Application by North Falls Offshore Wind Farm Limited (“the Applicant”) for an Order granting Development Consent for the proposed North Falls Offshore Wind Farm (“the Proposed Development”)

Response to Secretary of State Consultation 3 - 11.9 Applicant's Response to Secretary of State's Letter dated 28 January 2026 (Rev 0)

2.7 Applicant's Response to Design - Ref. 25

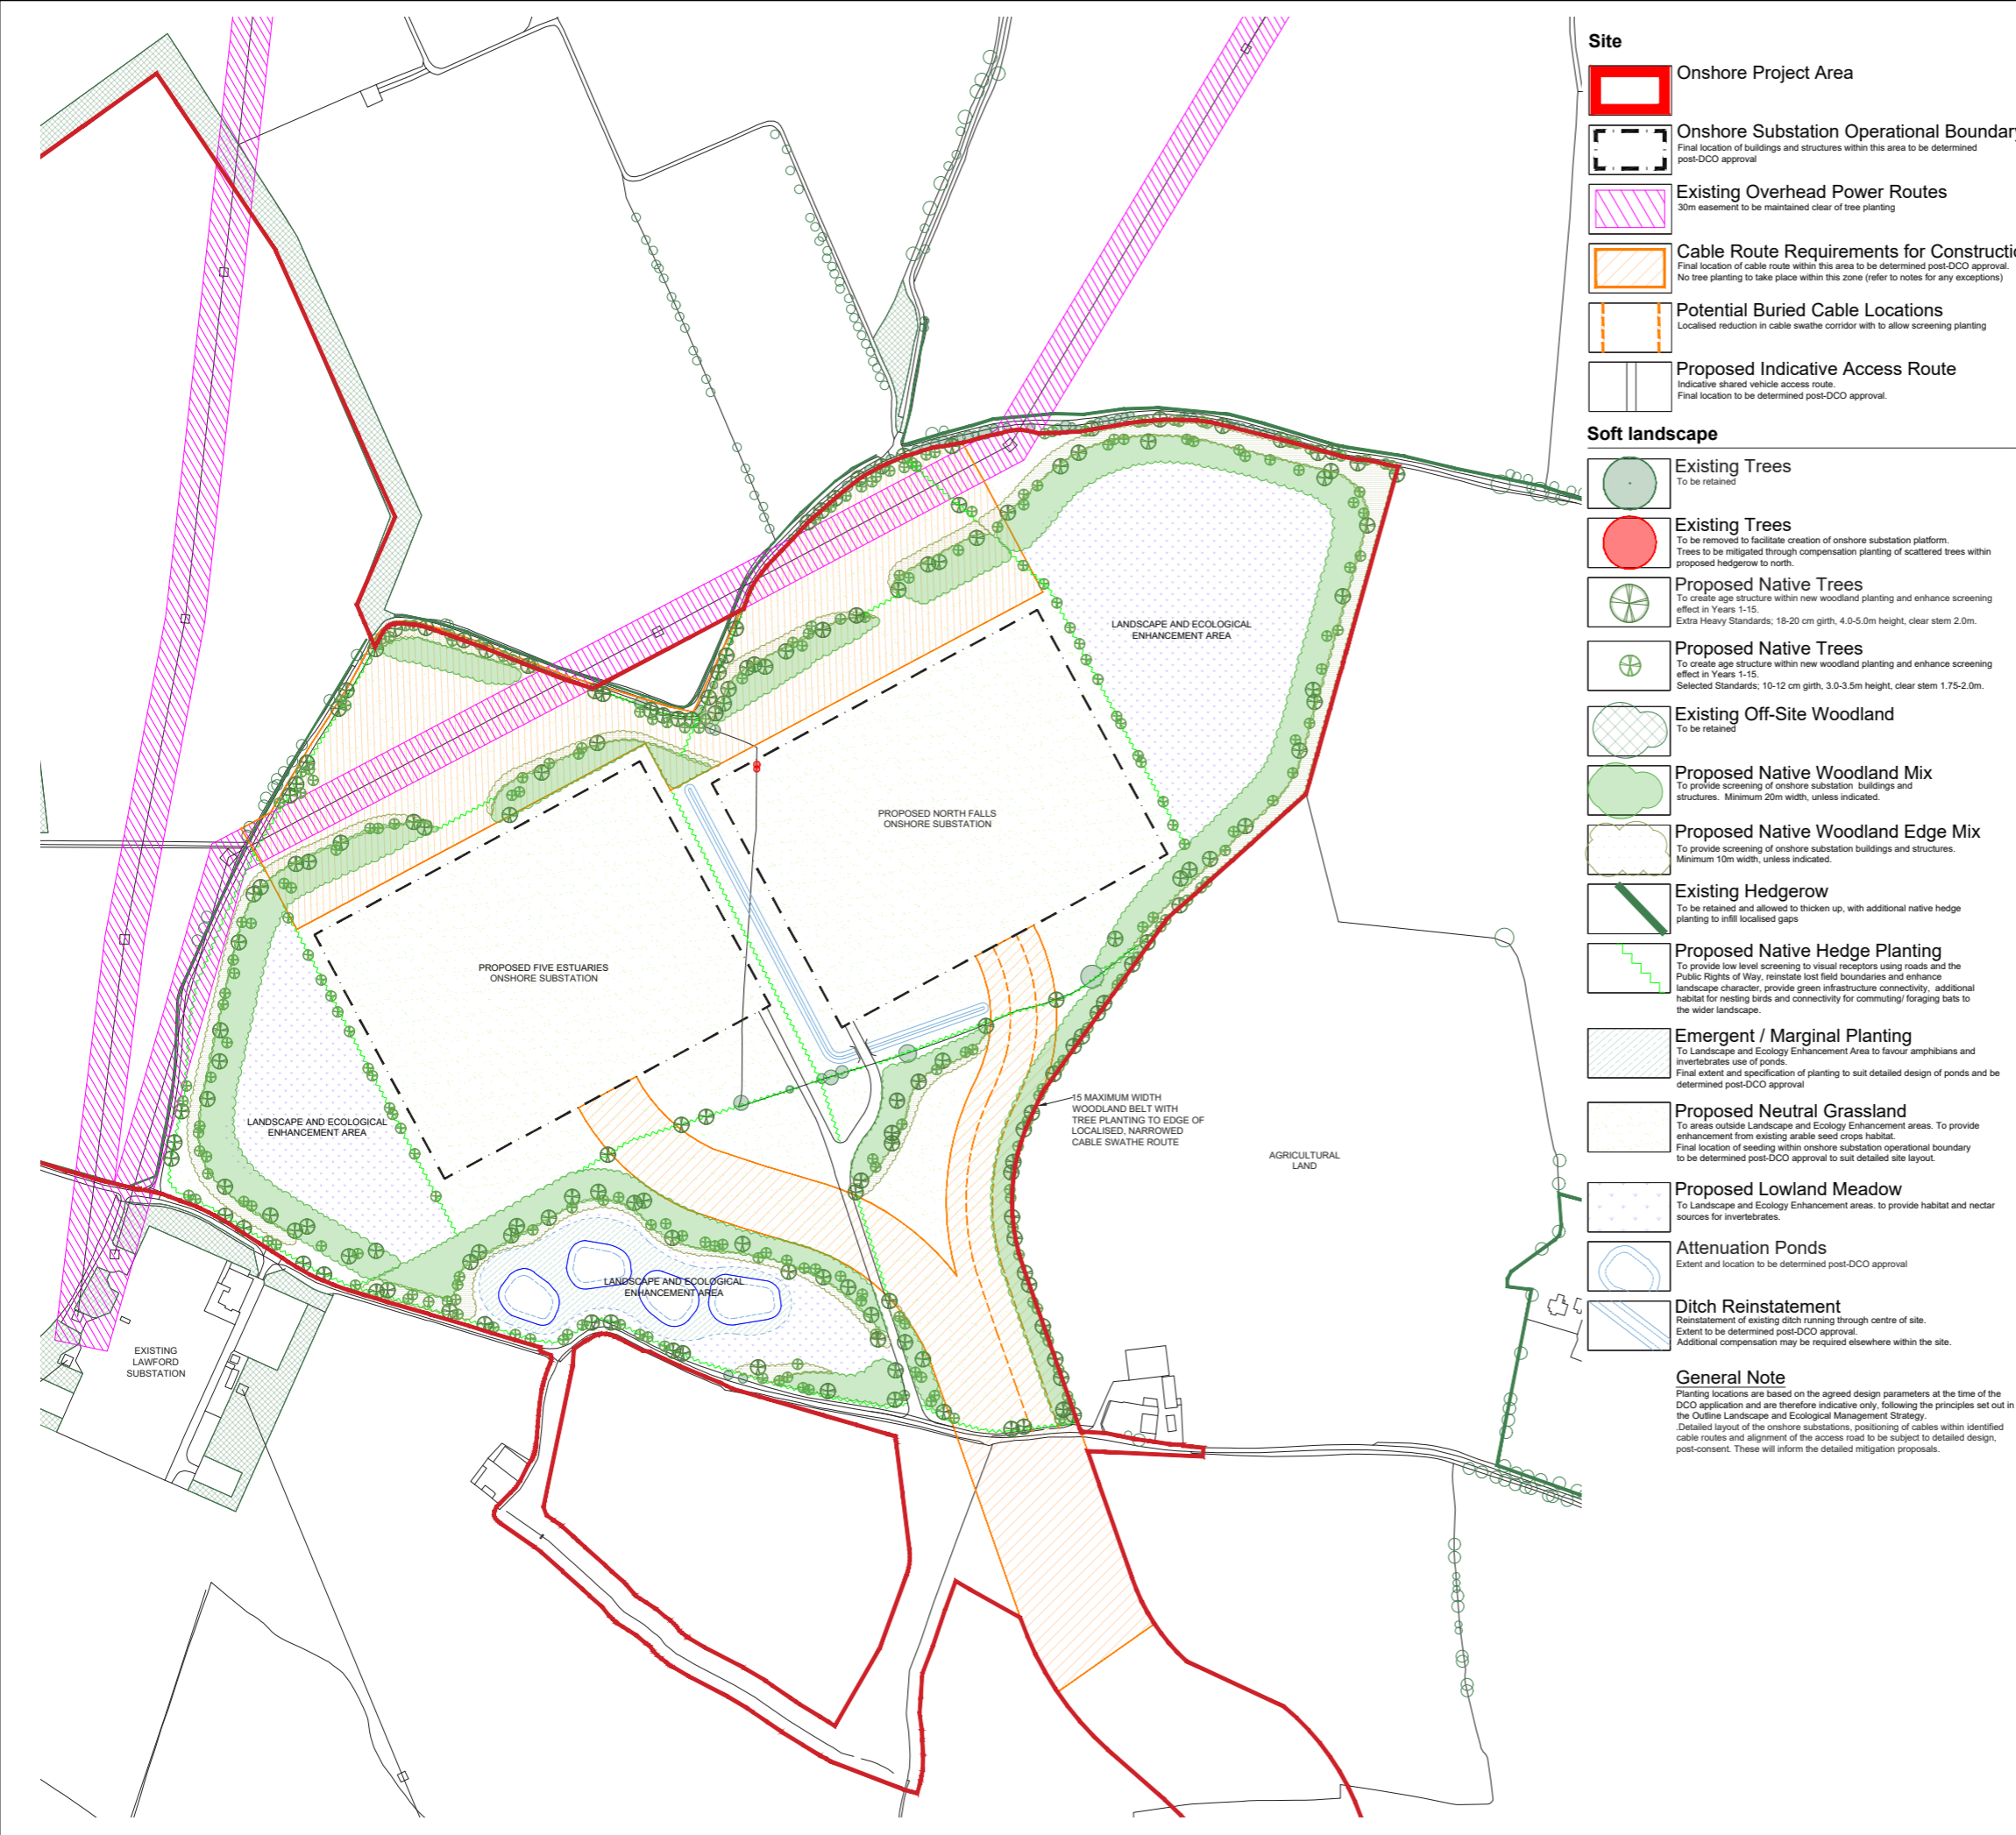
Based on a desktop assessment undertaken by the Councils, the potential encroachment associated with the proposed Ardleigh Road widening could affect a strip of land approximately 325 m in length and up to 25 m in depth. This equates to more than 8,000 m² of landscaping and planting area. The potential loss of land on this scale would amount to a substantial reduction from that shown in the outline landscape and ecological mitigation strategy/plan, and could materially affect the extent of BNG deliverable on-site.

Until detailed work plans and up to date landscape proposals from all three projects are overlaid and assessed together, supported by revised BNG calculations, the Councils cannot agree with the applicant’s position that the proposed road widening works would have no implications for the conclusions of the Environmental Statement. In the absence of such evidence, it is reasonable for the Councils to question whether the applicant can secure the level of BNG indicated in the DCO submissions. For this reason, it remains essential that the required BNG uplift is secured within the wording of the Requirements, to avoid the risk of significant deviation during later detailed design stages.

Furthermore, the current version of the JDG does not clearly confirm whether the proposed road widening strip, approximately 325 m in length and up to 25 m in depth, has been taken into account within the latest Landscape and Ecology Masterplan. There also appears to be a degree of conflation between the drainage easement requirements for the Norwich to Tilbury project and the land needed specifically for Ardleigh Road widening. As previously raised, these uncertainties mean that the Councils cannot be confident that the implications of these works would not affect the conclusions of the Environmental Statement.
